**MAIN LEVEL (BASEMENT)
FOR
MASTER PLAN**

DATE: 3/19/18
SCALE: AS SHOWN
JOB NO.: 1000
SHEET:
A 3.0

A 4.0

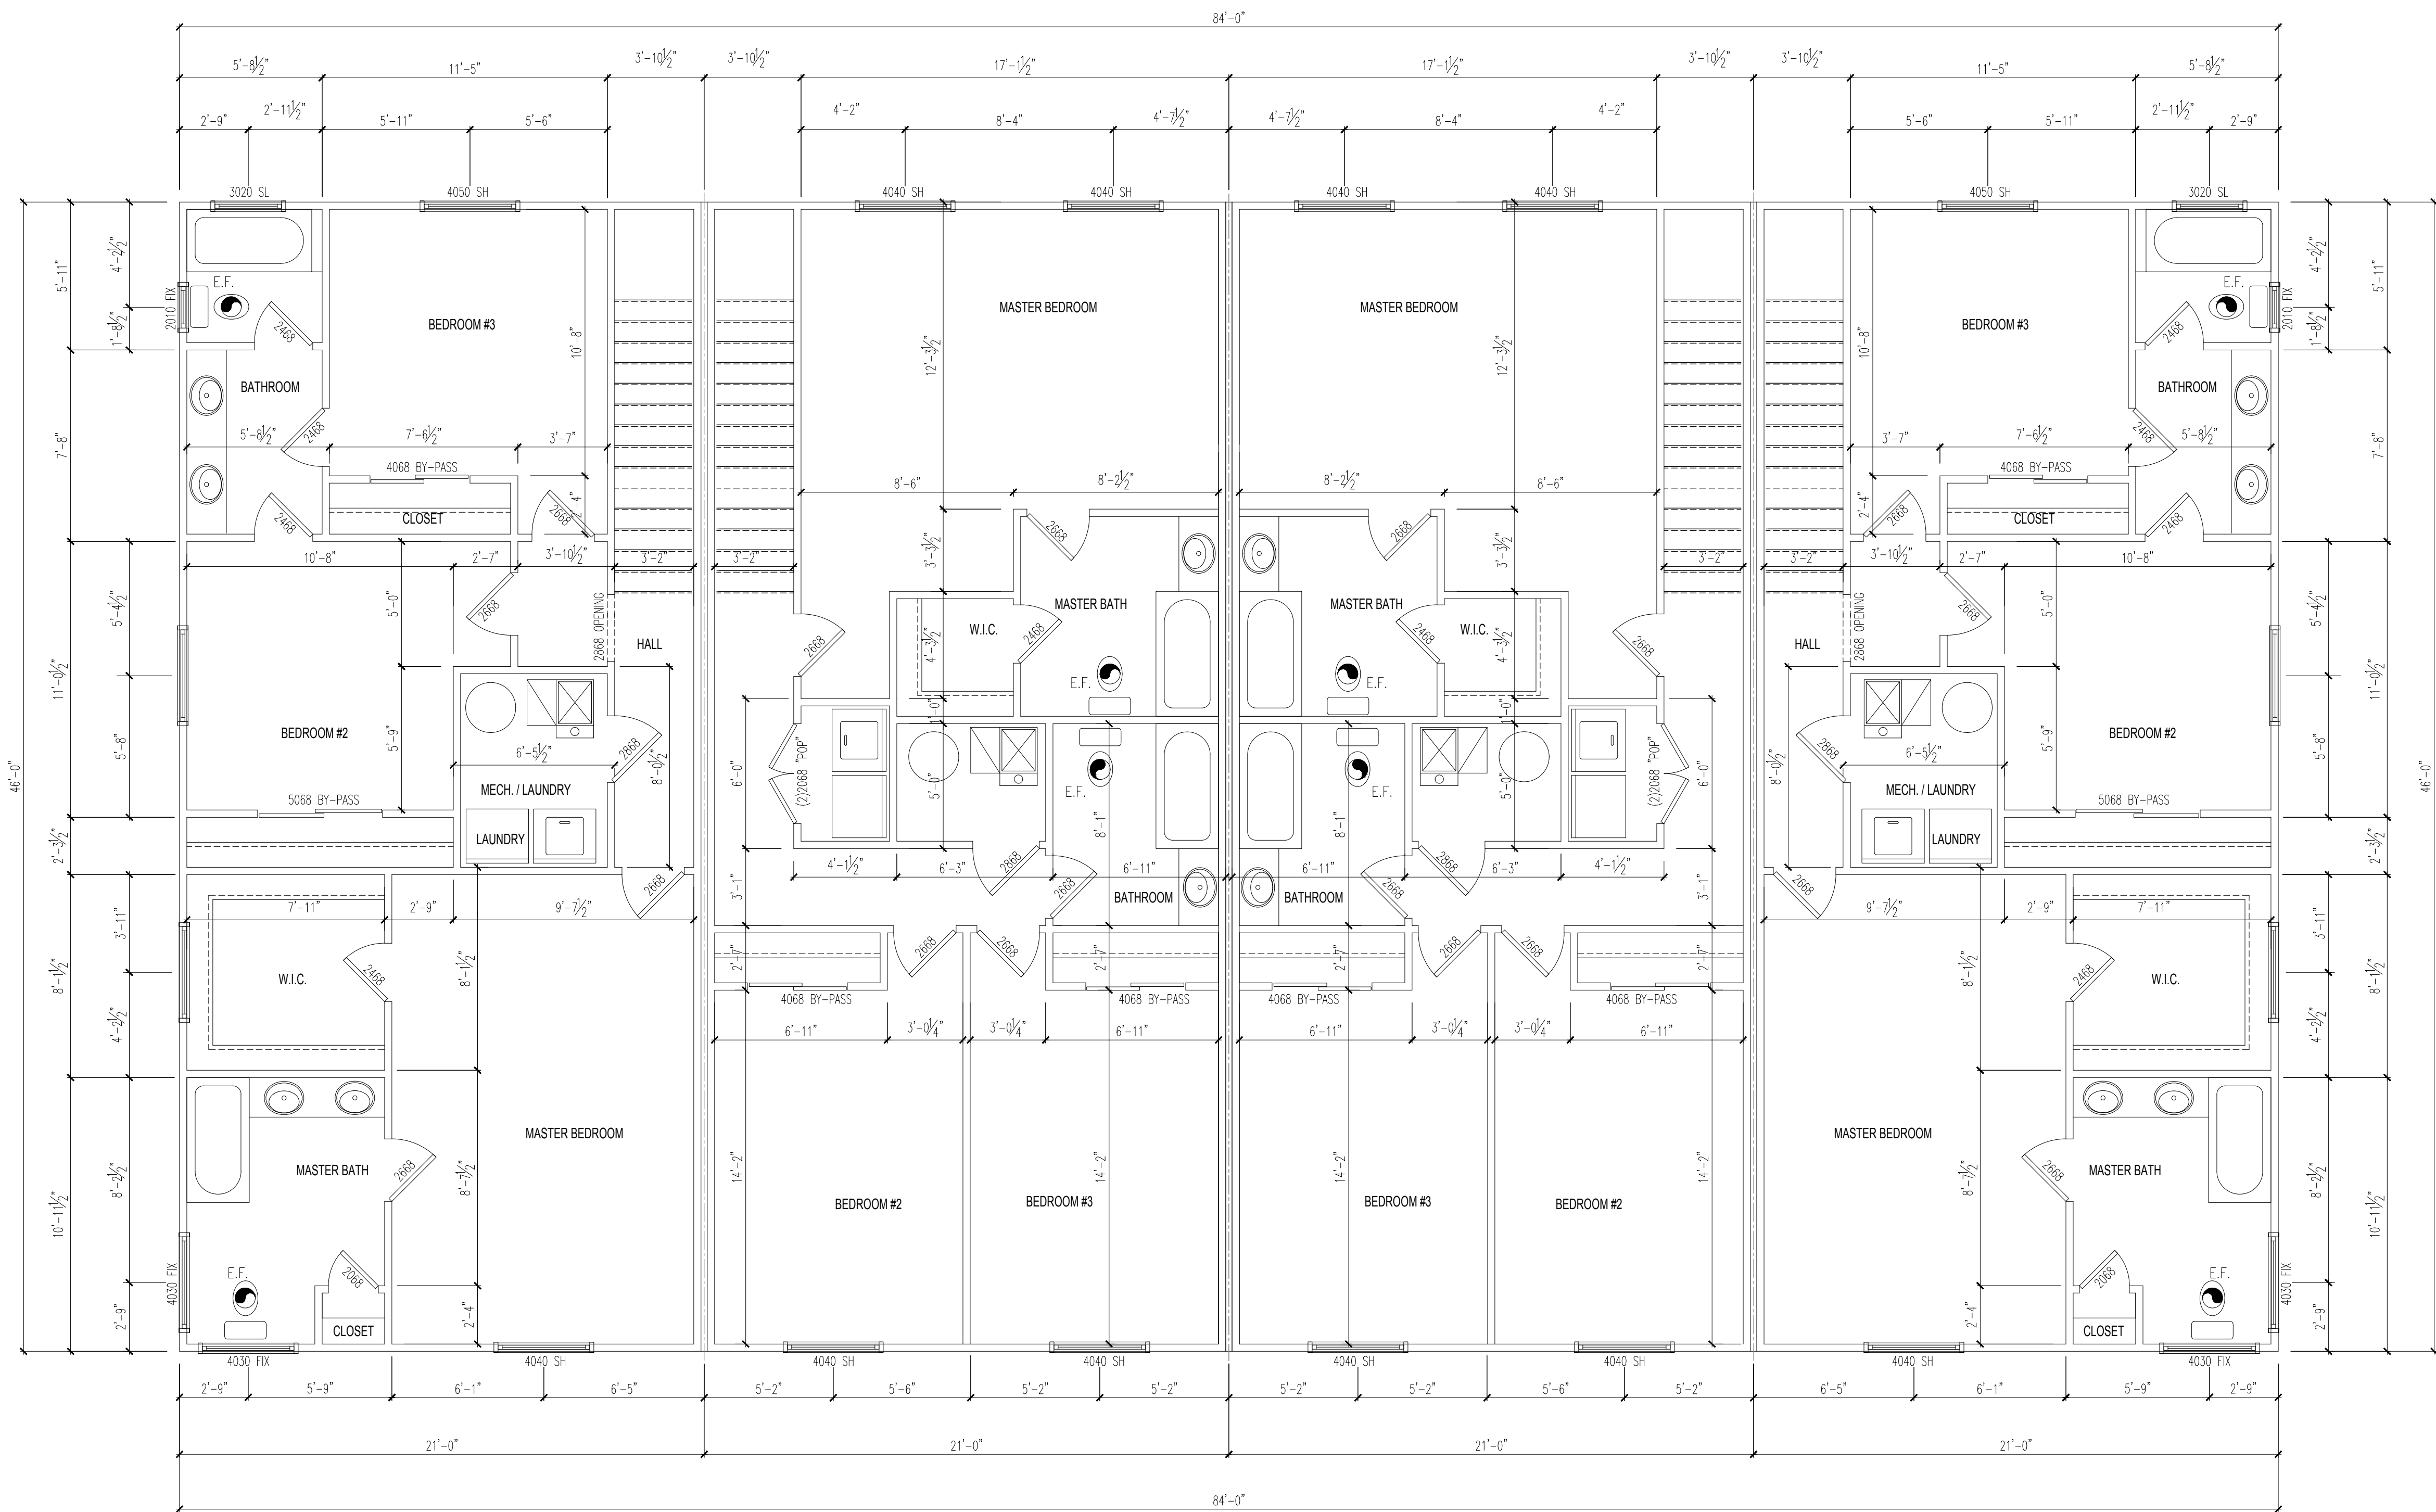
is this just storage area? unfinished area?

UPPER LEVEL (SLAB)

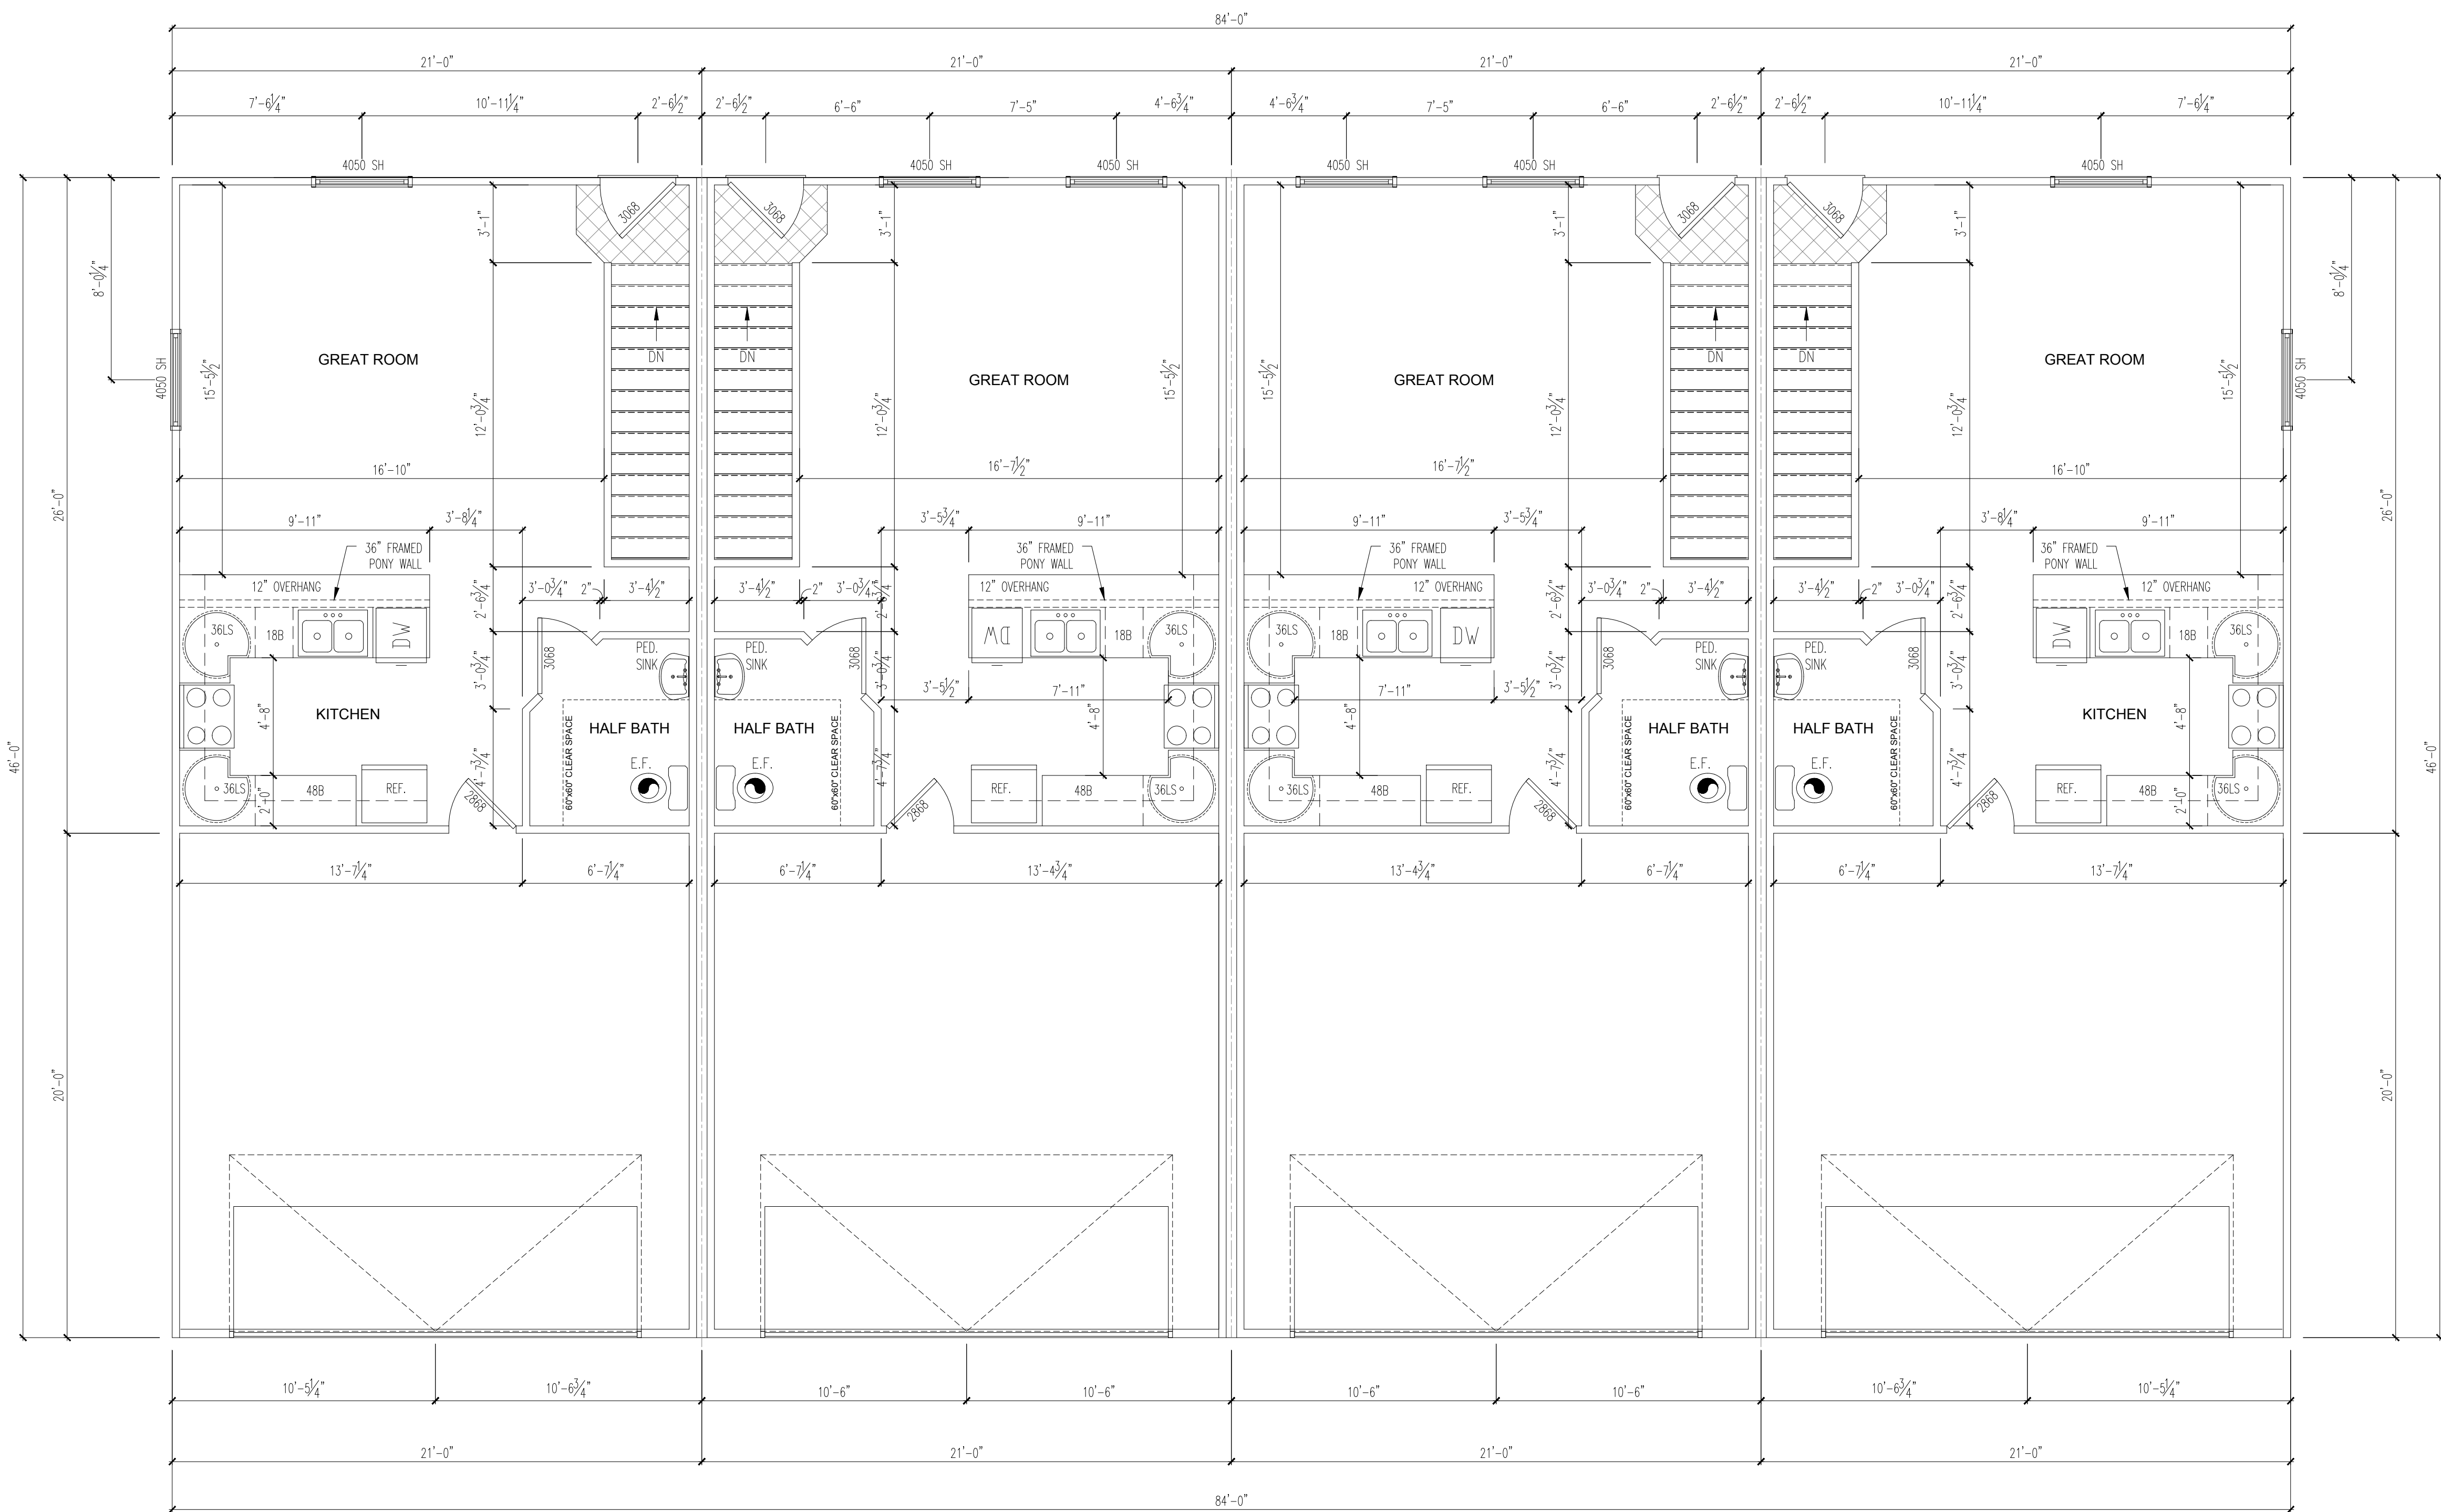
label different unit Types (all sheets)

which buildings are which unit types?
